WEST SUSSEX COUNTY COUNCIL CONSULTATION

TO:	Arun District Council FAO:Michael Eastman
FROM:	WSCC - Highways Authority
DATE:	9 December 2019
LOCATION:	Land between the A259 Worthing Road and East Street/Fitzalan Littlehampton BN17 7PP
SUBJECT:	LU/340/19/DOC Approval of details reserved by condition imposed under reference LU/63/11 relating to Condition Nos 4 - Construction Management Plan and 5 - vehicle cleaning facilities.
DATE OF SITE VISIT:	Meeting at WSCC on the 3rd December 2019
RECOMMENDATION:	Advice
S106 CONTRIBUTION TOTAL:	n/a

WSCC in its role of Local Highway Authority (LHA) has previously requested further additional areas of information from the applicant on their Construction Environmental Management Plan (CEMP). The latest CEMP revision C has now been provided by the applicant. In italics are the points previously requested by the LHA and the LHA's confirmation that these areas have now been addressed.

ii. Traffic Routes Offsite

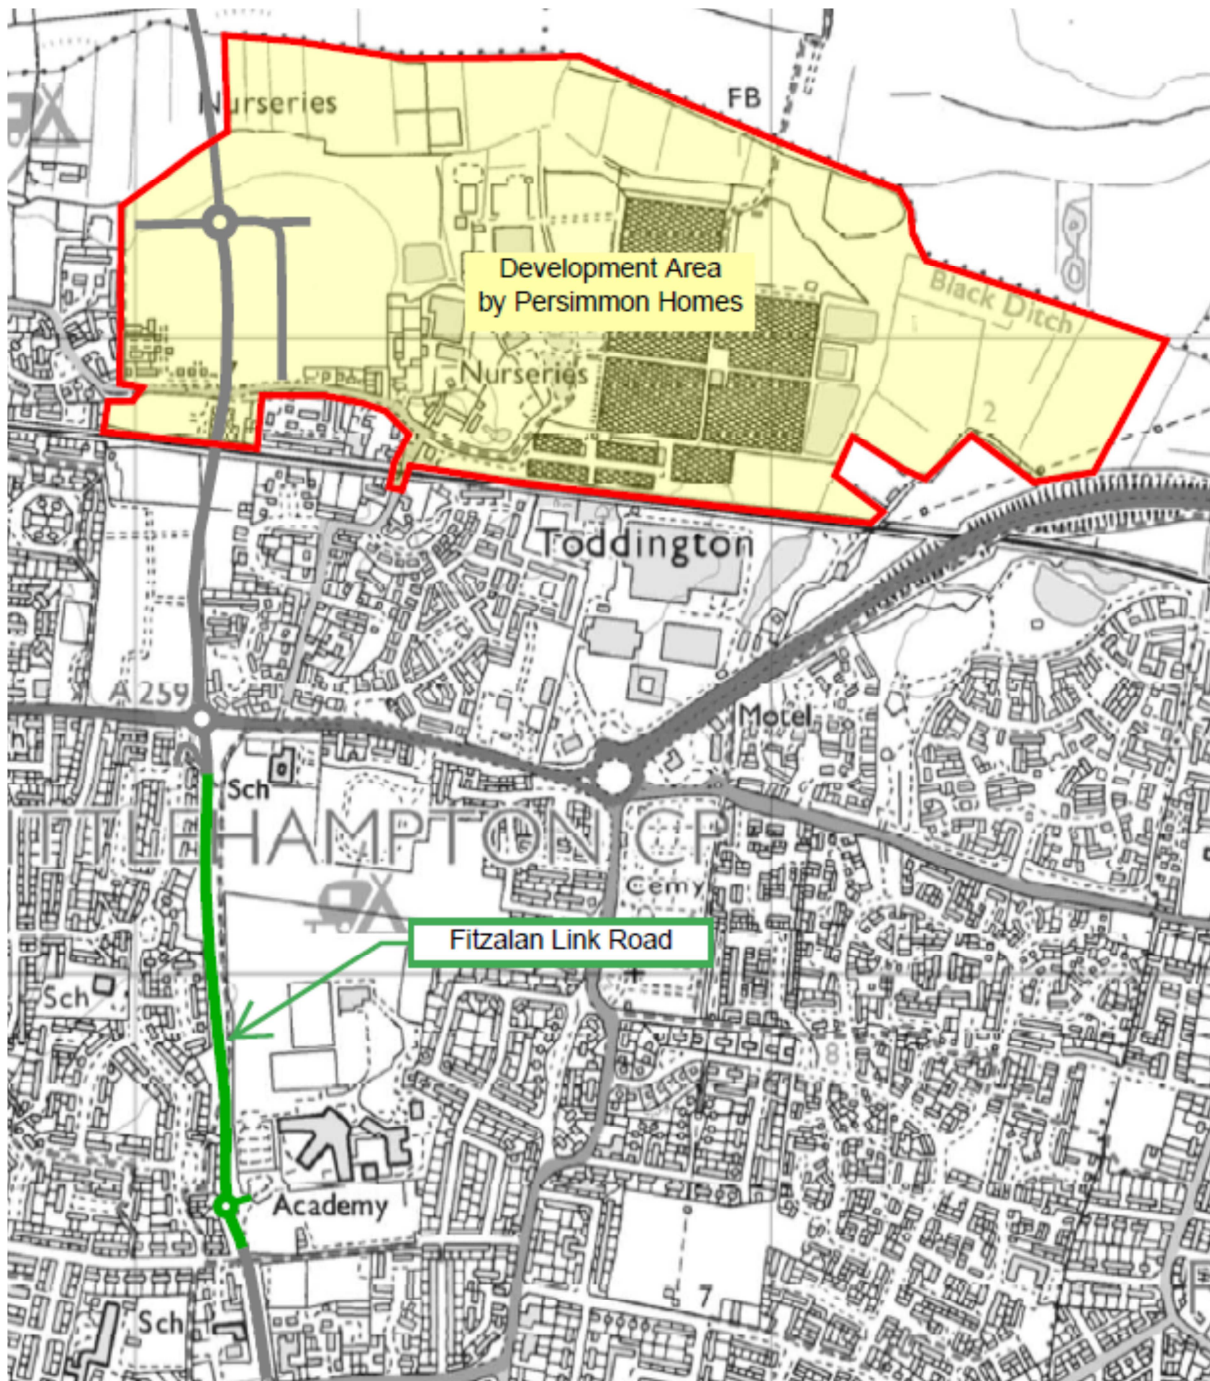
- There is no indication of where traffic will be entering from when they enter Richardson Way off Toddington Lane. We would look for the applicant to submit details of the proposed construction traffic routes from the A27 and that these be on the most appropriate routes as far as is practicle. **Access to this point will be from the A27 (north) or A259 (south). Confirmation has been made that no deliveries will be via the residential area east of the main compound.***
- It is not apparent how vehicles and materials are transported from the compound to get to the southern and northern sections of the road. **Site vehicles and small deliverers will enter the compound and directed***

LYMSTER SOUTHERN BYPASS & FITZALAN LINK ROAD

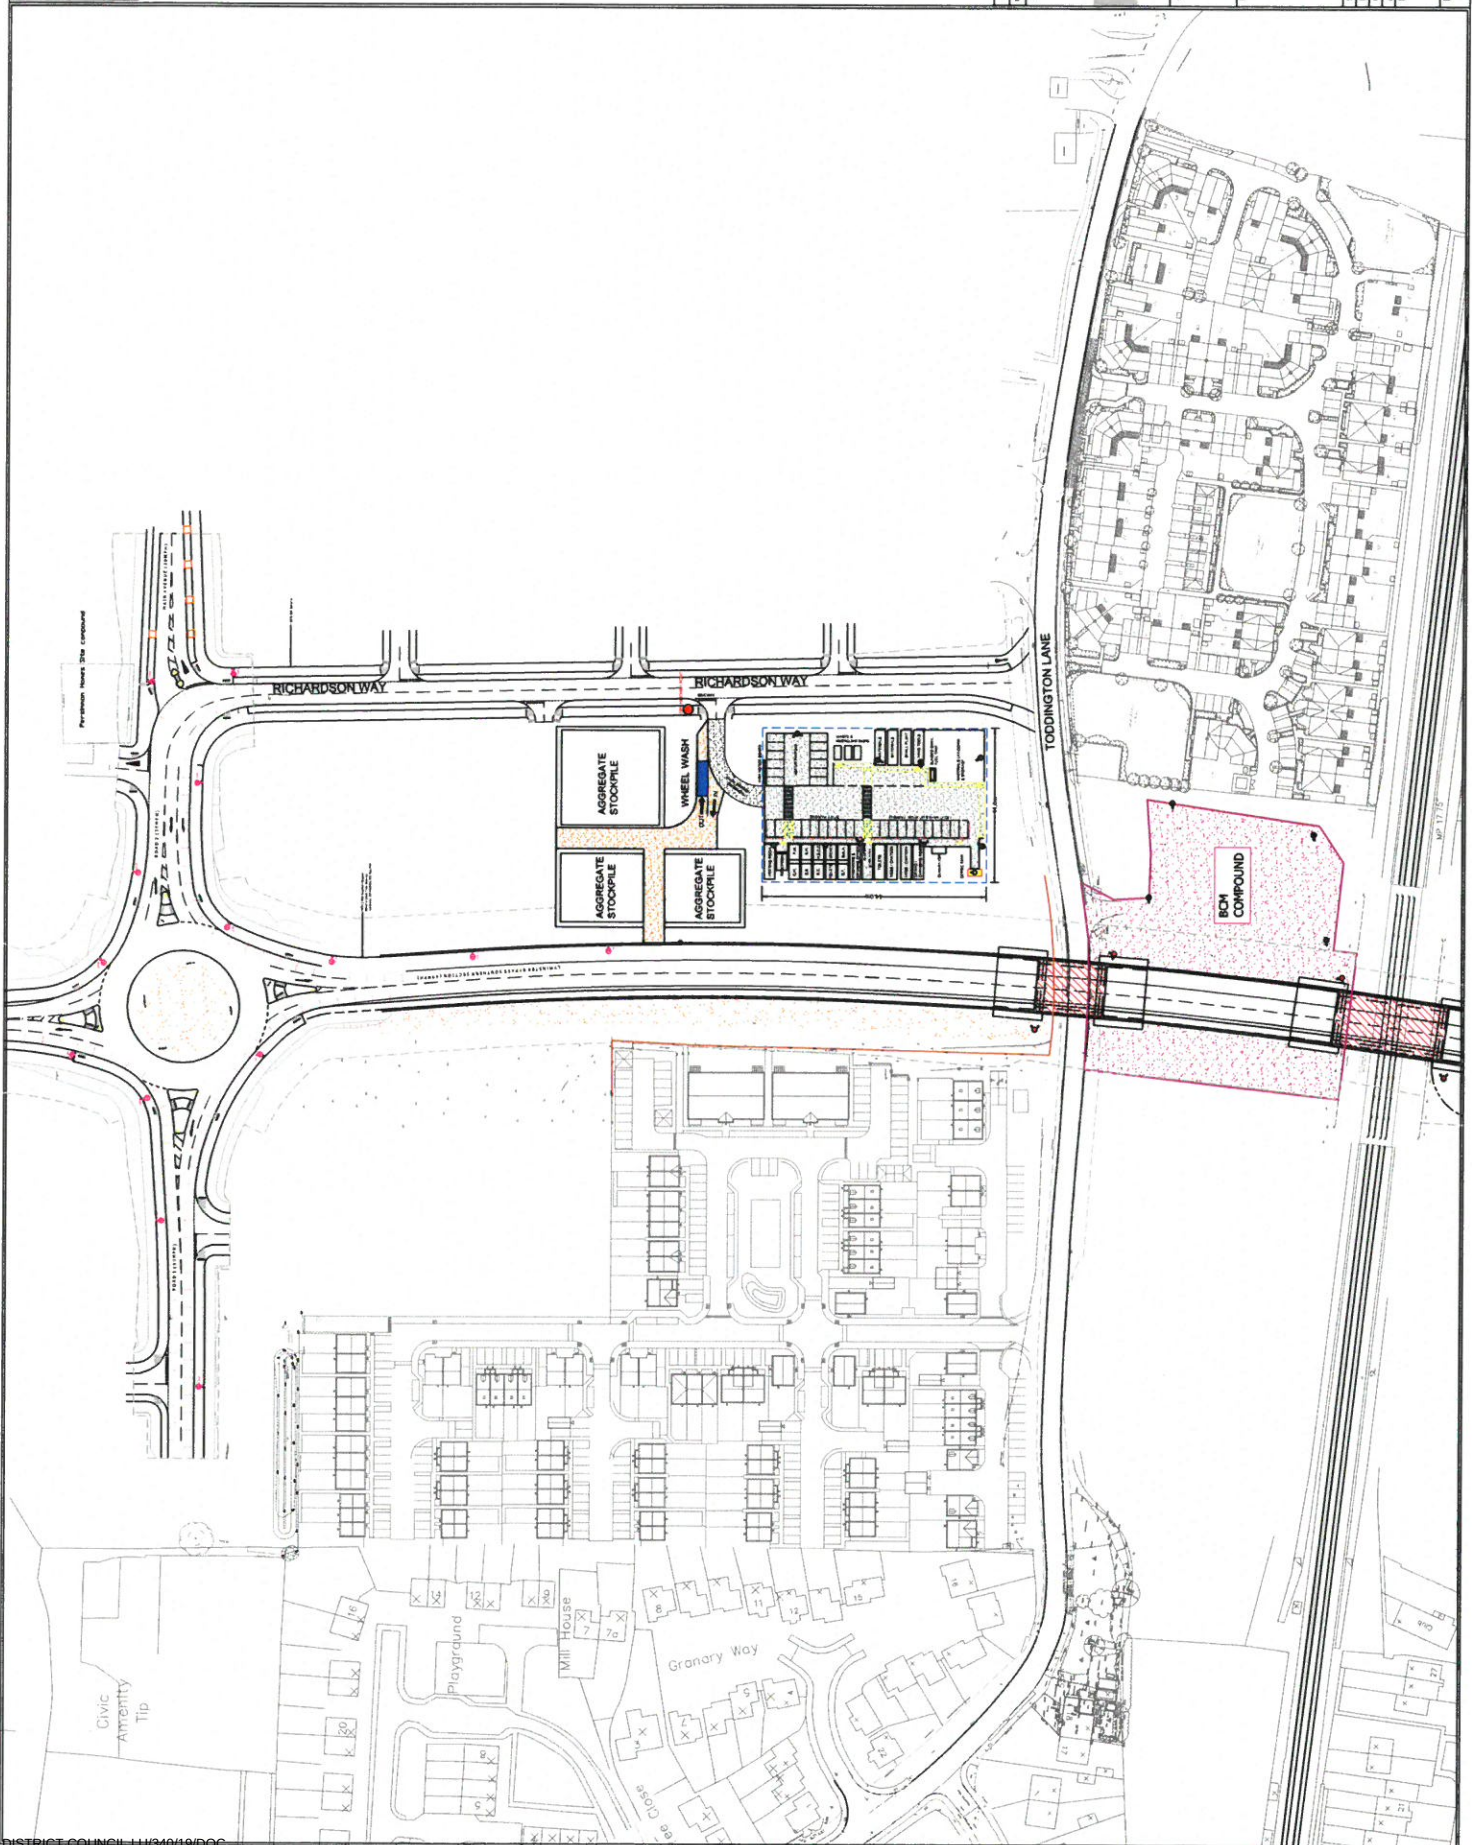
- *Parking areas have not been demonstrated i.e not shown or laid out therefore difficult to know how much contractor parking could be housed. Clarification on the level of parking and its design and layout should be provided. **Contractor parking of 40 spaces is located in the main compound off Richardson Way, the applicant has provided this in Appendix C of their CEMP.***
